Our ref: HMS ID 2221

Sandstone Precinct Mod 18 - Lands Building Ceilings (SSD-7484-Mod-18) – Lands Building Ceilings

The proposed modification involves demolition and replacement of ceilings and cornices on the lower ground, ground and level one of the Lands Department Building and the removal of the Lyon and Cottier Coat of Arms.

Figure 27 – Flat Ceiling Detail - Option B

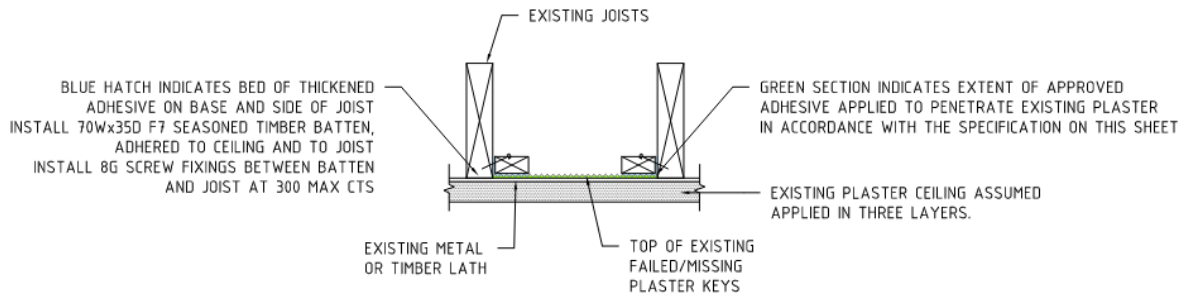
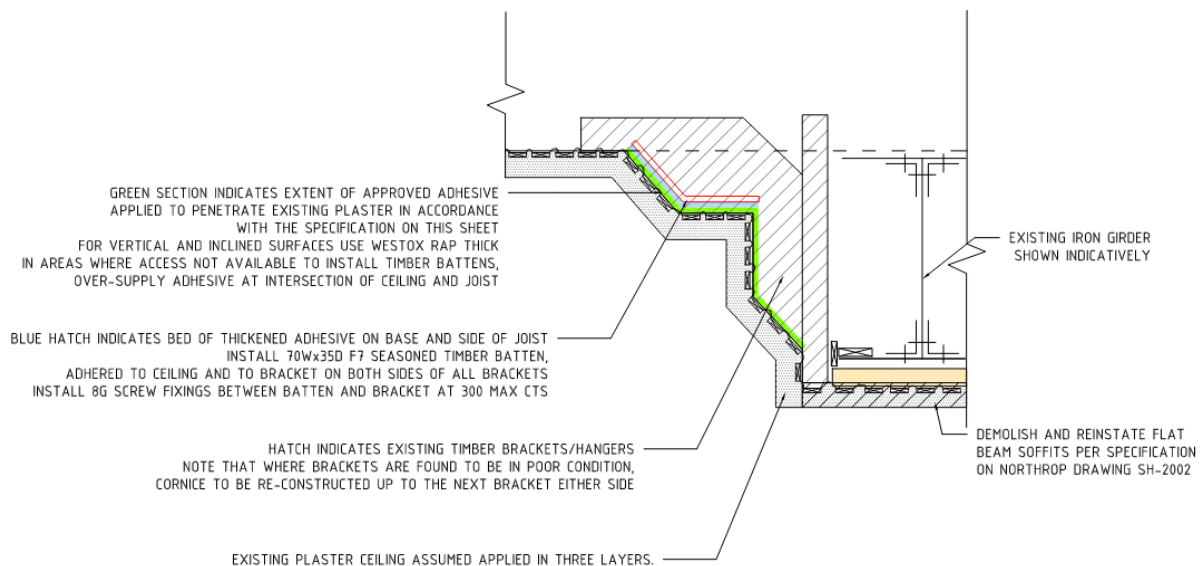
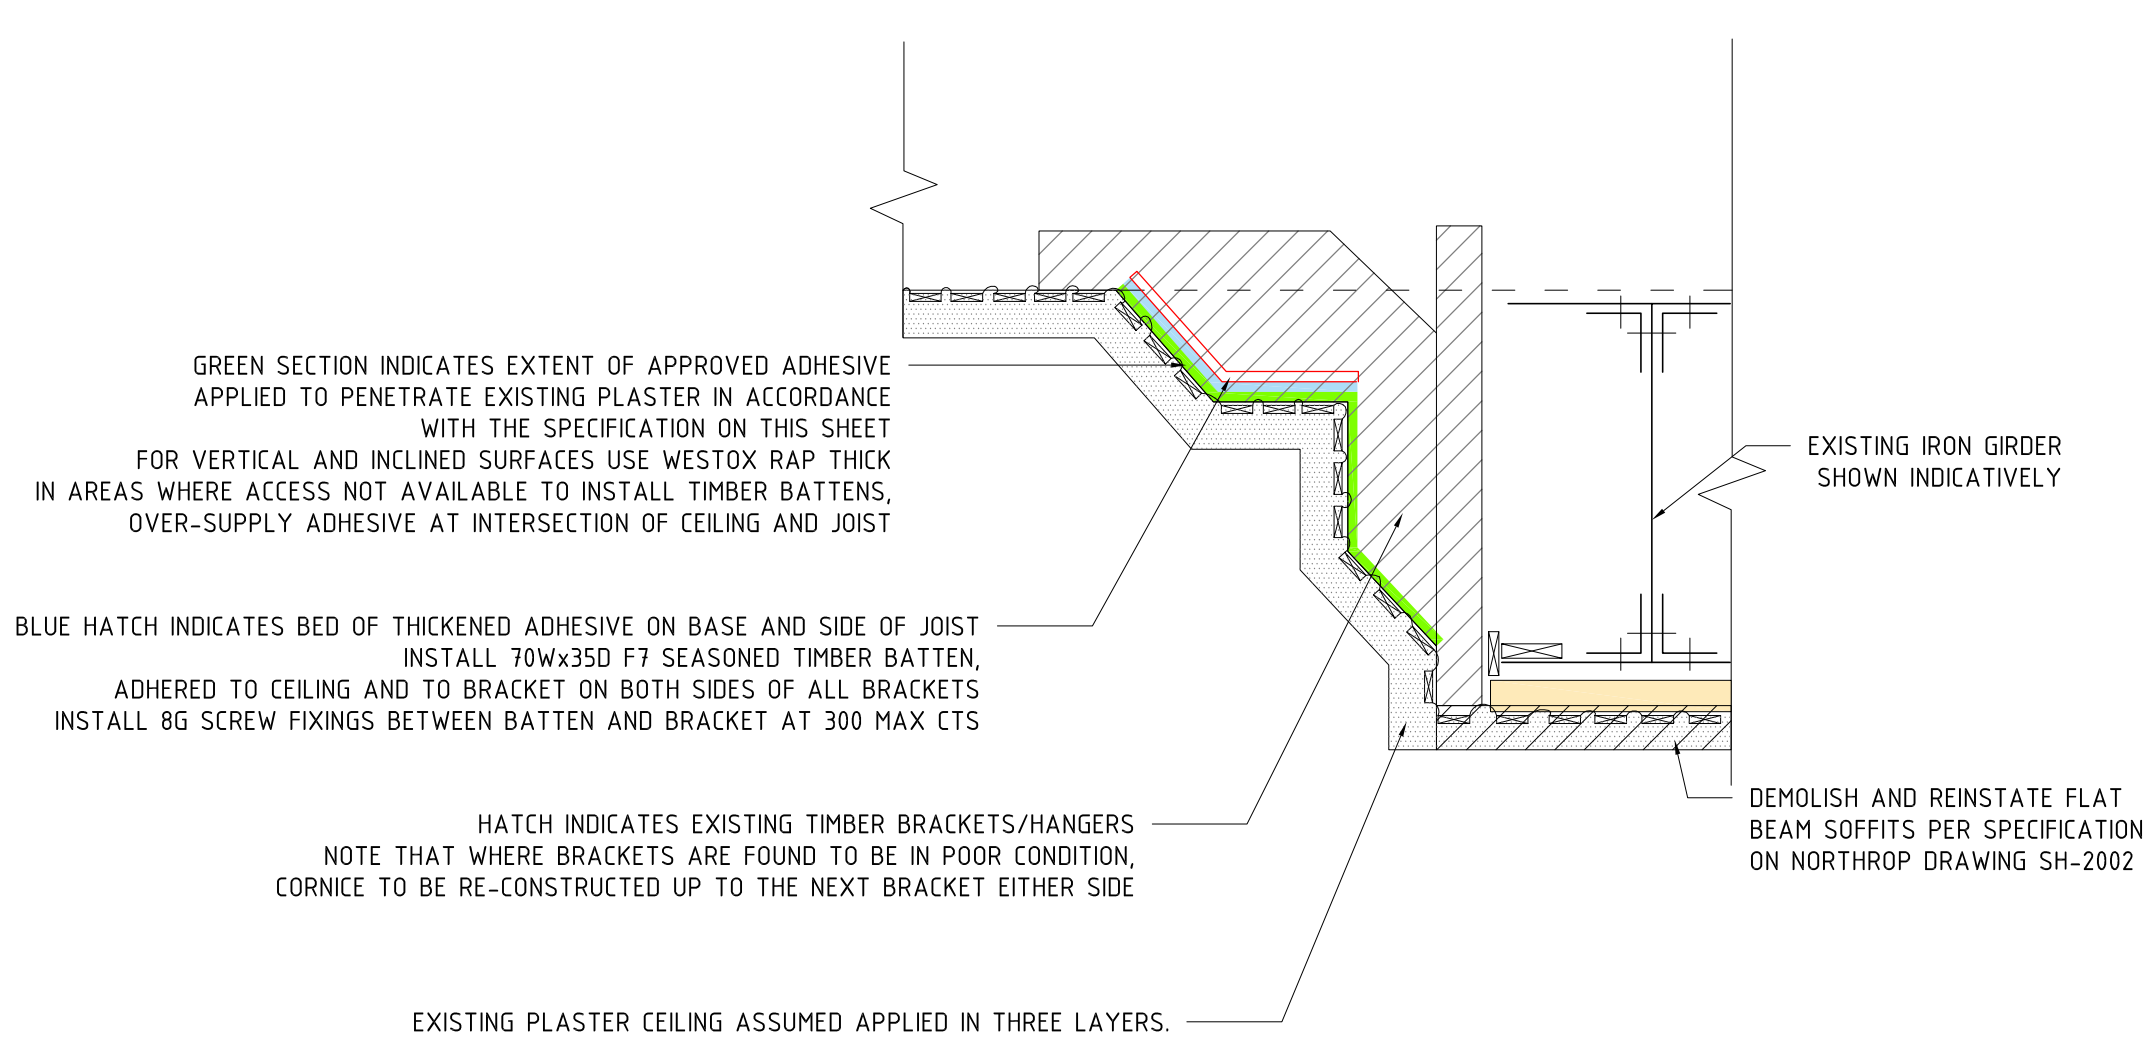
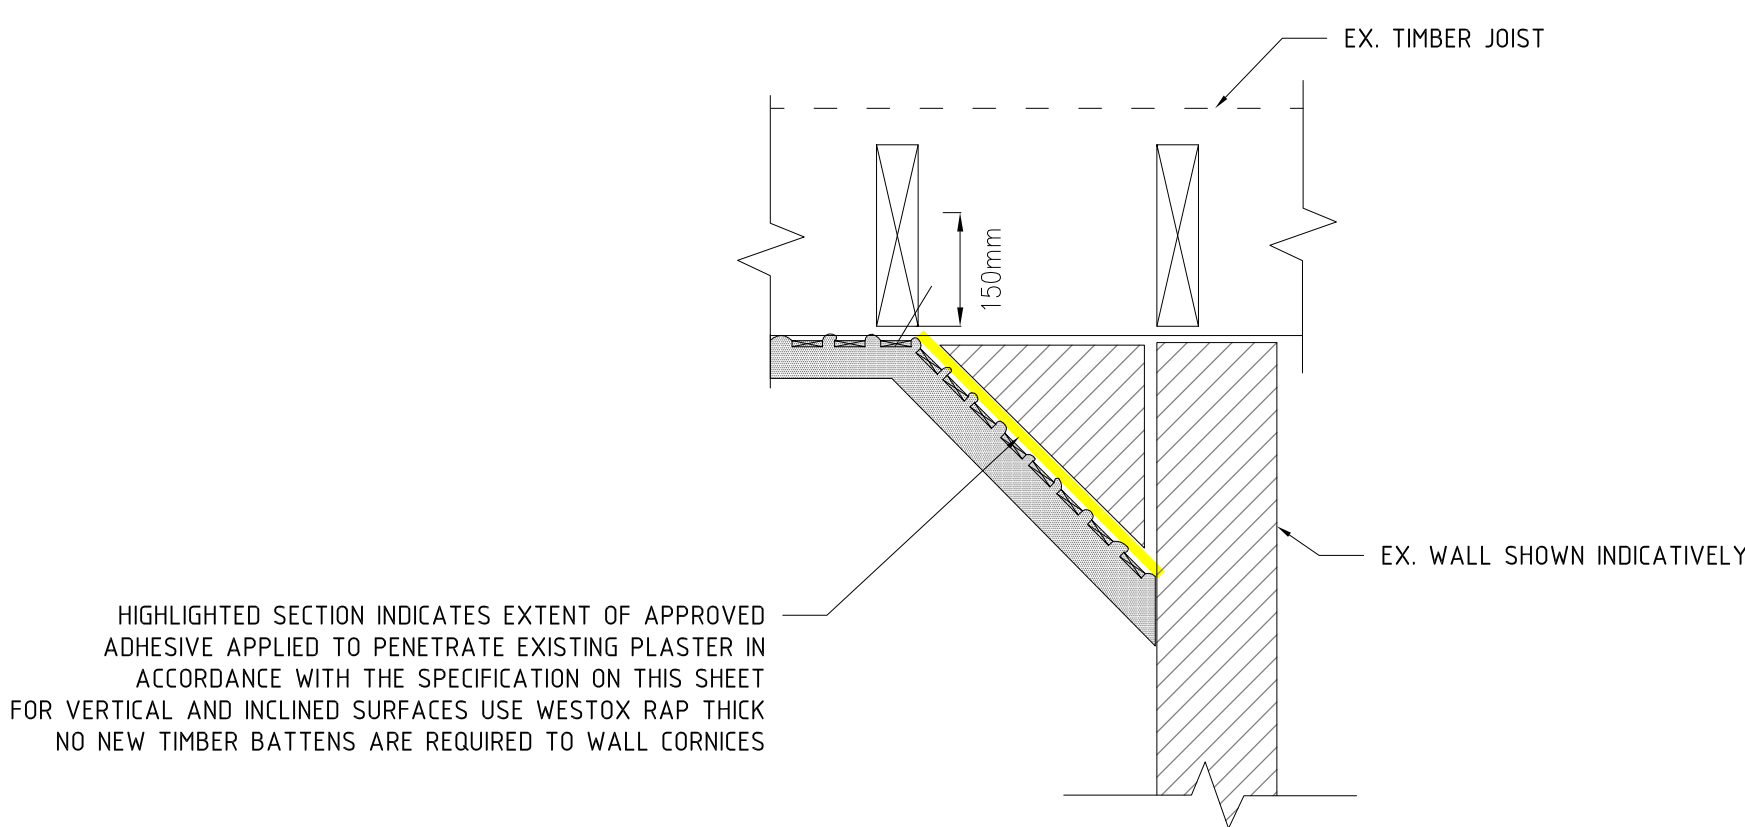
stabilisation of the lath and plaster ceilings. Timber block attachment and adhesive (Option B) is the option preferred by the consultants (Northrop) and involves:

- initial repair and ongoing maintenance of the plaster
- treating the topside of the ceiling with Westox primer and adhesive (or approved alternative)
- using new timbered battens to fix the top of the existing lath and plaster ceiling to the existing joists. The battens are secure through chemical adhesion (Westox RAP thickened adhesive) and mechanical fixing (skew screws).

For the beam and wall cornices, Northrop recommend that the treatment is very similar using a primer and adhesive. A seasoned timber batten shaped to fit the cornice geometry is imbedded in the thickened adhesive and mechanically fastened to the existing cornice brackets with screw fixings.

A conservation methodology that conserves the lath and plaster ceilings and the concrete arch ceilings is supported.

Northrop in their report noted that if their preferred method of conservation were to be applied the risk of major failure/collapse is low.
